MONA OFFSHORE WIND PROJECT

Annex 7.2 to the Applicants response at the Procedural Deadline

Figure updates to address inconsistency between Onshore Works Plan and Environmental Statement figures - Reports

Document Number: MOCNS-J3303-RPS-10234

## Figure 1.1: Location of the Mona Offshore Wind Project.

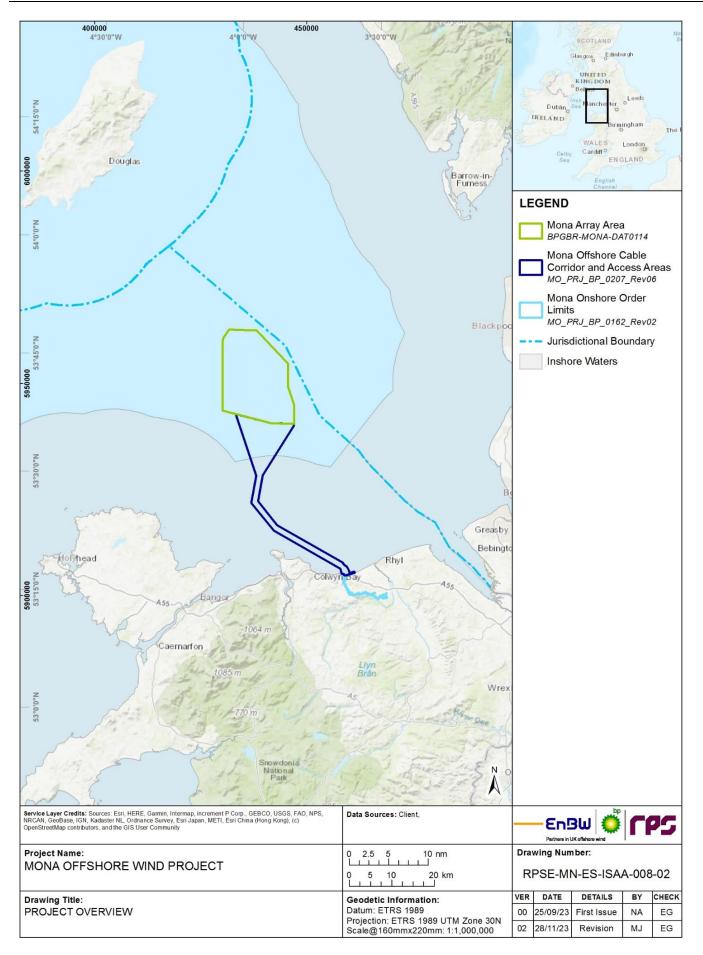
Para 12.1 of the Application Letter (Doc A1) states that the proposed operational access to the existing National Grid Substation from the proposed Mona Substation access from Glascoed Road has been assessed in the Environmental Impact Assessment (EIA) but part of it is not currently shown on all the EIA figures.

The Inspectorate advises the Applicant to undertake a thorough audit of the ES figures to ensure that they are consistent with the Onshore Work Plan (Doc B3). Amended ES figures should be provided, together with a list of the figures subject to amendment.

1.2.1.1 The Applicant has updated the figures of the Environmental Statement and other relevant application document figures as appropriate to show the proposed operational access to the existing National Grid Substation from the proposed Mona Substation access road. The figures that have been updated is provided below.

Figure 1.1: Figure 1.1 of HRA Stage 2 ISAA Part One: Introduction and Background (APP-031).
